Our Ref: 20/01230/HOU
Your Ref:

LOCATION: 50 Allcot Road, Portsmouth, PO3 5DF, ,

PROPOSAL: Construction of double storey rear extension. **(20/01230/HOU)**

EXISTING ELEVATIONS. 1/100 @ A3

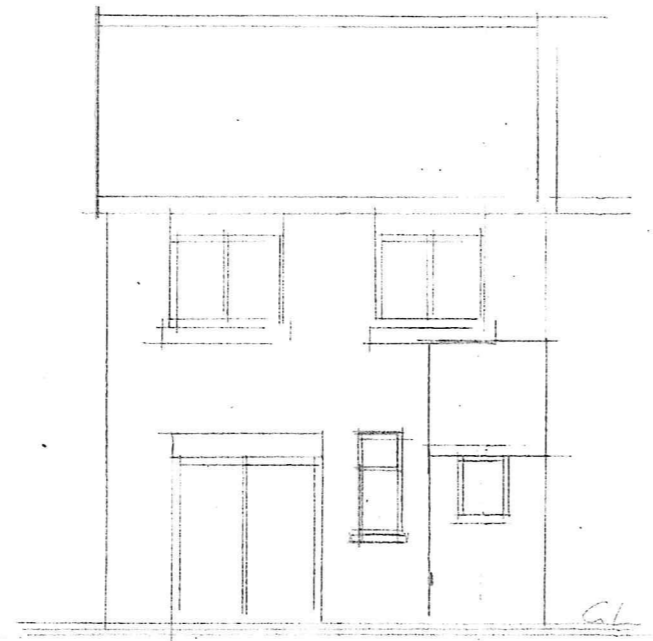
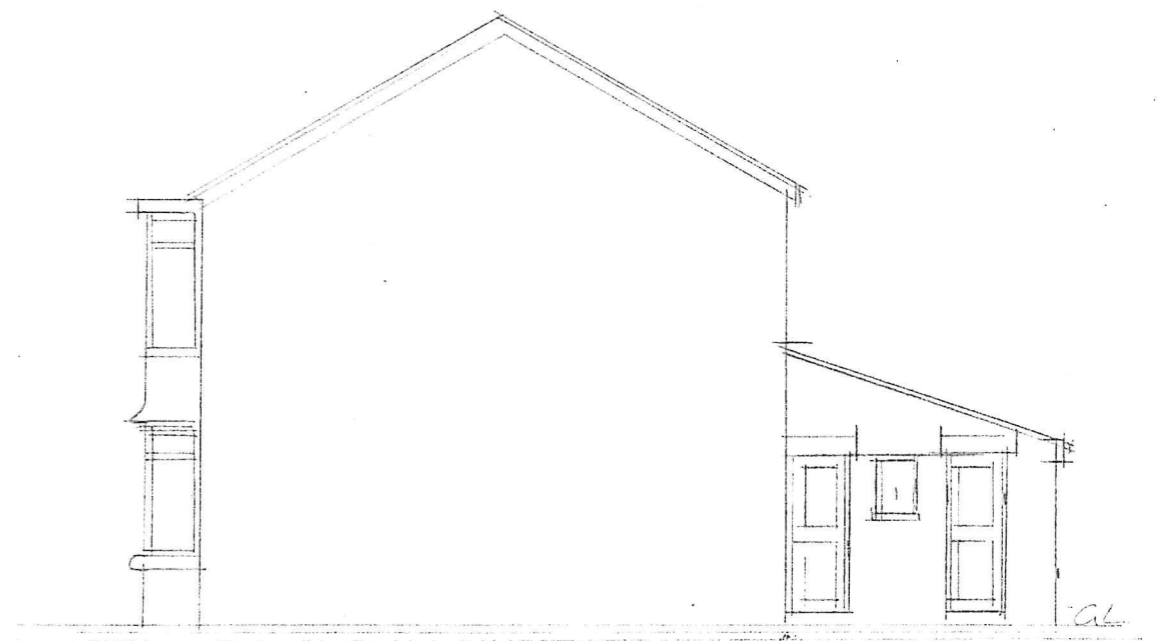
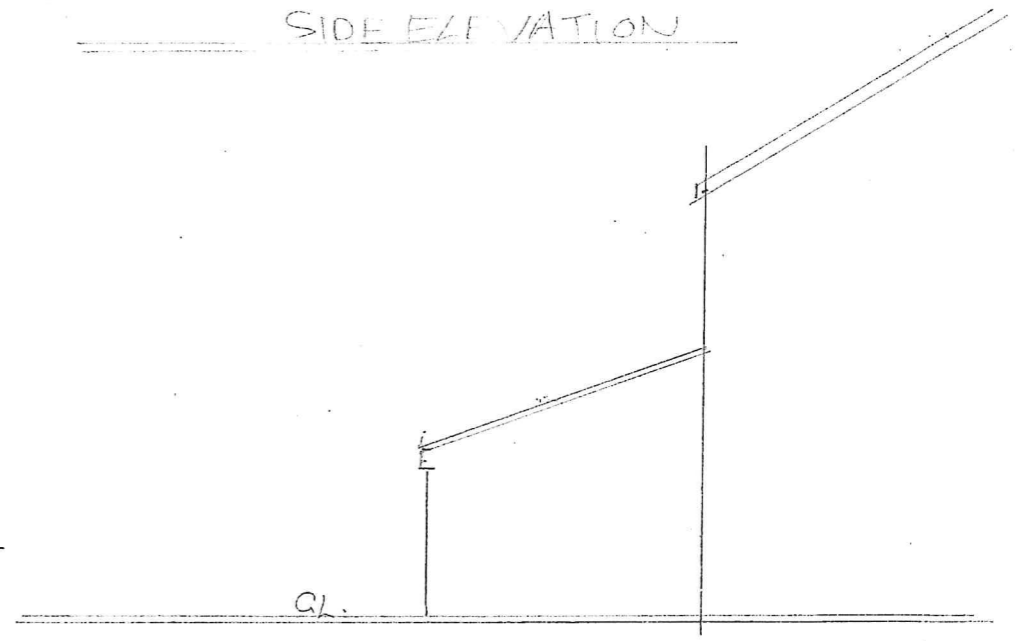
- 1) It is a requirement that all drawings are accompanied by scale bars for every sized used. Please resubmit your drawings with the appropriate scale bar(s) included.
- 2) Please provide the other side elevation for existing and proposed plans showing the proposal/alterations. Please submit this at a stated standard metric scale such as 1:50 or 1:100, with a scale bar or dimensions annotated to allow the confirmation of the scale
